Development Facilitation Team (DFT) – Review Comments

DRB Project No: PR-2021-004968 Date: 02/07/2024 Agenda Item: #8 Zone Atlas Page: C-10

Legal Description: TRACT B-2-A-1, LA CUENTISTA SUBDIVISION

Application For: SD-2024-00020 – FINAL PLAT (DHO)

**Plat for  
La Cuentista Subdivision, Phase II  
Being Comprised of  
Tract B-2-A-1, La Cuentista  
Subdivision, Phase I  
City of Albuquerque  
Bernalillo County, New Mexico  
January 2024**

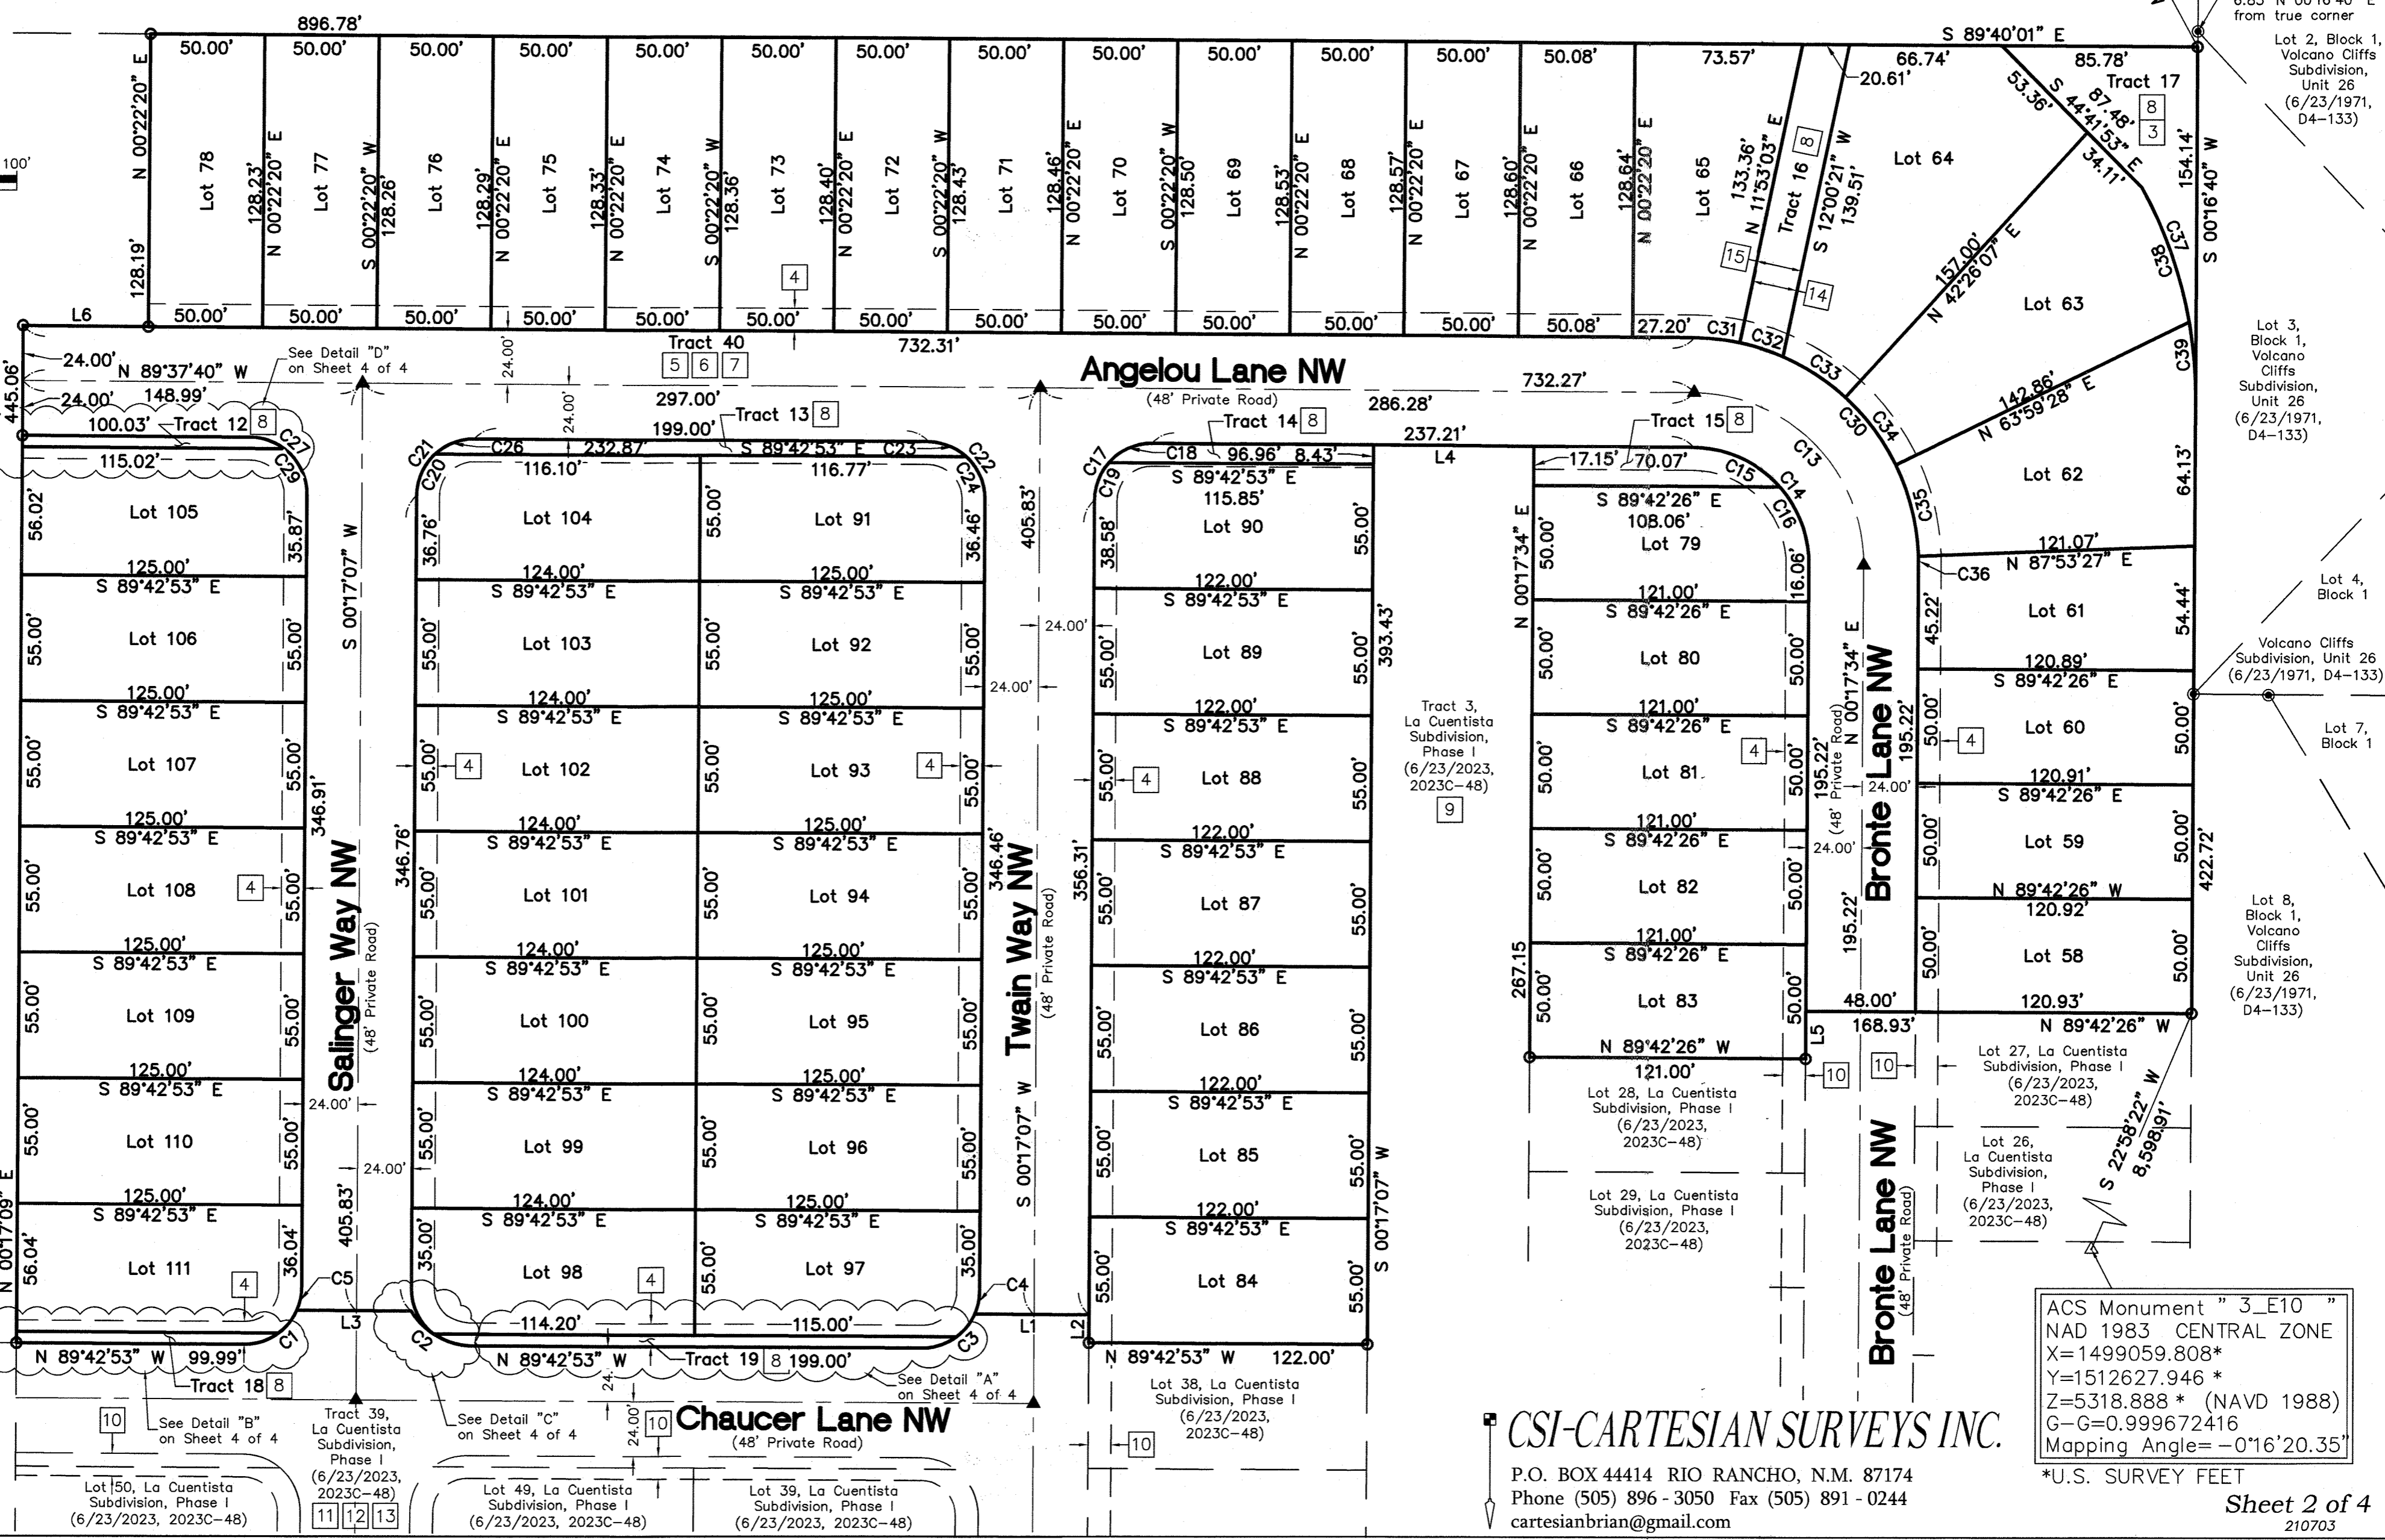
1. Please elaborate on what type of surface is being proposed on Tract 16.
 - a. The exclusive easements are preferred.
2. Add the following note on the plat when easements are being granted for public water and/or public sanitary sewer infrastructure.

- Plat is showing the subject tract within Phase II, however application description is showing Phase I. Please confirm if this was a typo.
- Modify the Waiver Note to exclude "and the Environmental Planning Commission" and replace with "on March 30, 2022." The DRB approved the waivers associated with this plat.
- Add project and application numbers to the plat.
- Property owner's signature is required on the plat.

- Per 6-6(L)(2)(d)(7) of the IDO, the date of the DHO approval shall be recorded on the Final Plat.
- The DXF file must be approved by AGIS, and the approval email from AGIS must be submitted prior to the final sign-off from Planning should the Plat be approved by the Development Hearing Officer.
